Developer Services
Southern Water
Sparrowgrove House
Sparrowgrove
Otterbourne
Hampshire
SO21 2SW

Your Ref
BR/201/18/HH
Our Ref
PLAN-024401
Date
19/09/2018

Proposal: Demolition of existing side attached garage and rear utility lean-to and proposed construction of a single storey side and single storey rear extension.
Site: 10 Sturges Road, Bognor Regis, PO21 2AH.
BR/201/18/HH

Drawing:
Block plan showing boundary dims.

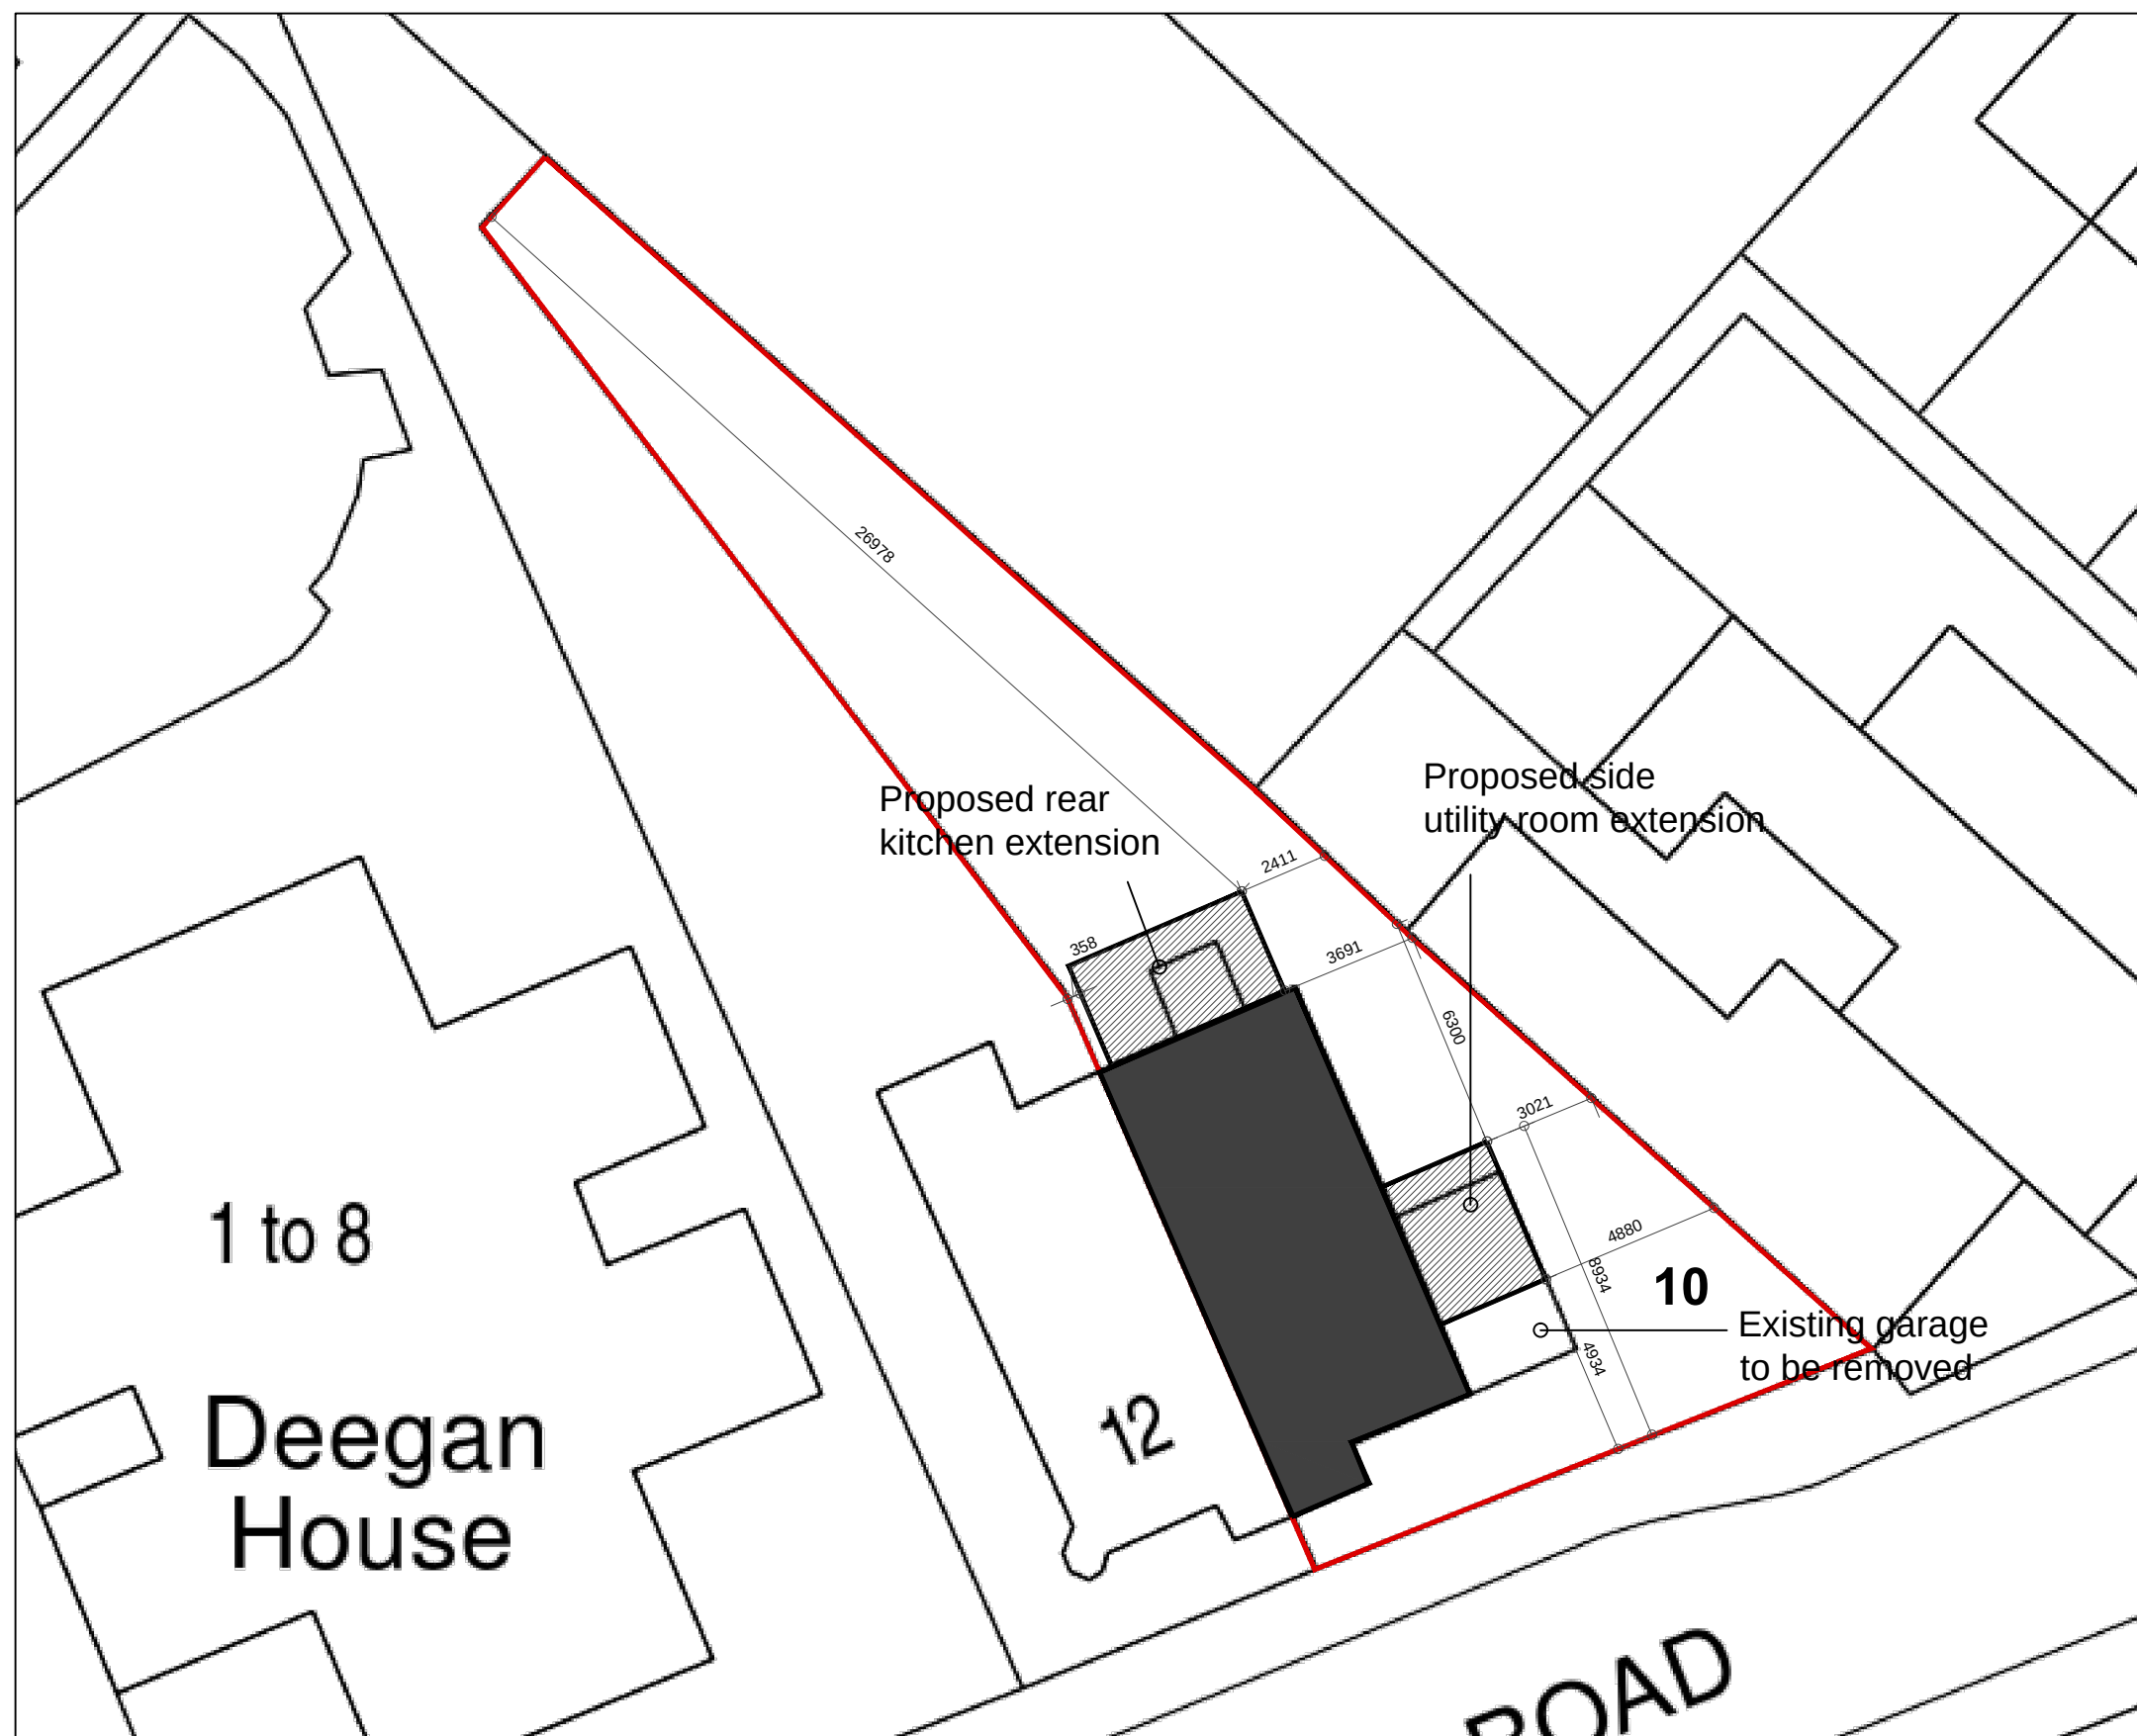
It appears that the developer is intending to build over to a public foul sewer which is crossing the site. Building over a "public sewer" is not normally permitted by Southern Water.

However, under certain circumstances building over a minor sewer may be allowed. The conditions associated with the build over/close to a sewer are contained in Southern Water guidance notes which are available at: www.southernwater.co.uk. A formal application to build close to the sewer will required to be submitted by the applicant.

In order to protect drainage apparatus, Southern Water requests that if consent is granted, a condition is attached to the planning permission For example: "The developer must agree with Southern Water, prior to commencement of the development, the measures to be undertaken to protect the public sewer."
